**COMMUNITY SERVICES DEPARTMENT**

**Subject: Bennett Ranch Sketch Plan Amendment (SKP-203)**

The Planning Division of the Community Services Department has reviewed the Bennett Ranch – Judge Orr Eastonville Sketch Plan Amendment and has the following comments on behalf of El Paso County Parks. This application will be presented to the El Paso County Park Advisory Board on October 11, 2020.

BENNET RANCH SKETCH PLAN

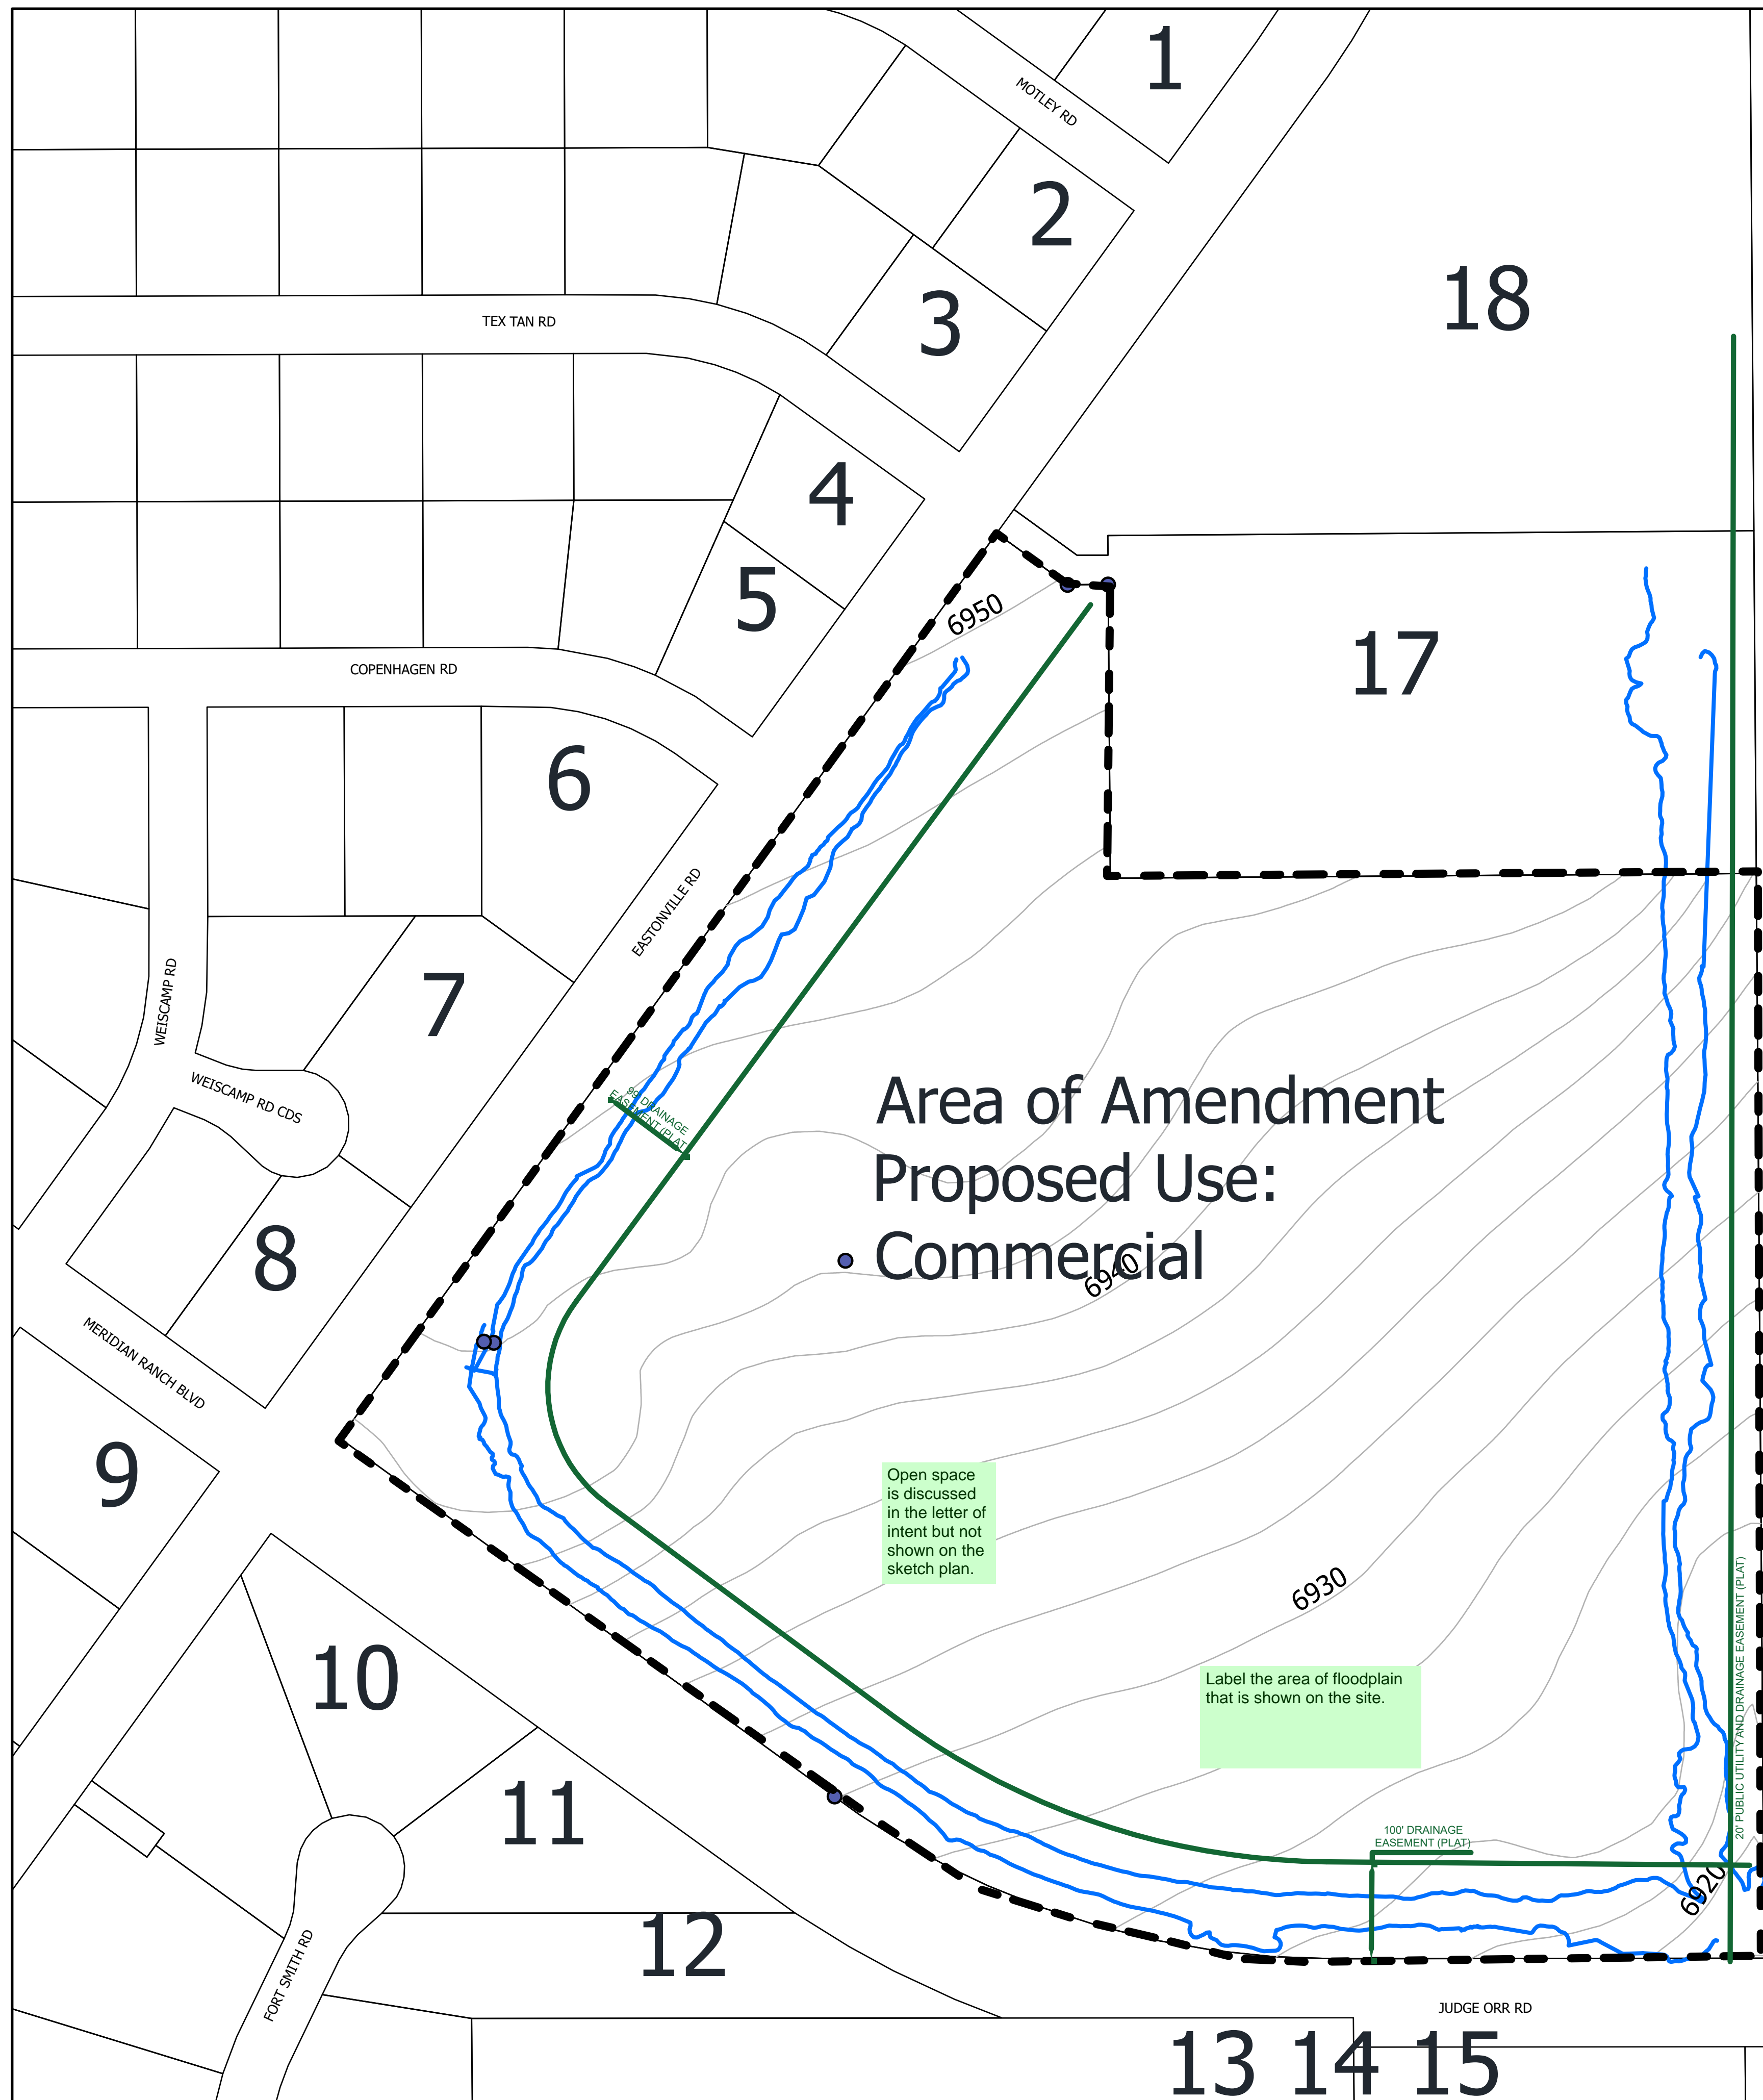
As it pertains to this application, the County requests that the landowner provide a 25-foot public trail easement along the east side of Eastonville Road that allows for the construction and maintenance by El Paso County of a primary regional trail, and this easement shall be shown and dedicated to El Paso County on the Final Plat. In addition, the County requests that the landowner provide a 25-foot public trail easement along the north side of Judge Orr Road that allows for the construction and maintenance by El Paso County of a secondary regional trail, and this easement shall be shown and dedicated to El Paso County on the Final Plat. Dedications for the aforementioned trails may occur within the existing drainage easements between the public right of way and the wetland boundary.

*The Park Advisory Board recommends that the Planning Commission and the Board of County Commissioners include the following conditions when considering and/or approving the Bennett Ranch Sketch Plan Amendment: (1) Provide a 25-foot public trail easement along the east side of Eastonville Road that allows for the construction and maintenance by El Paso County of the Eastonville Regional Trail (2) Provide a 25-foot public trail easement along the north side of Judge Orr Road that allows for the construction and maintenance by El Paso County of the Judge Orr Regional Trail (3) Both regional trail easements may occur within the existing drainage easements between the public right of way and the wetland boundary and shall be shown and dedicated to El Paso County on the Final Plat.*
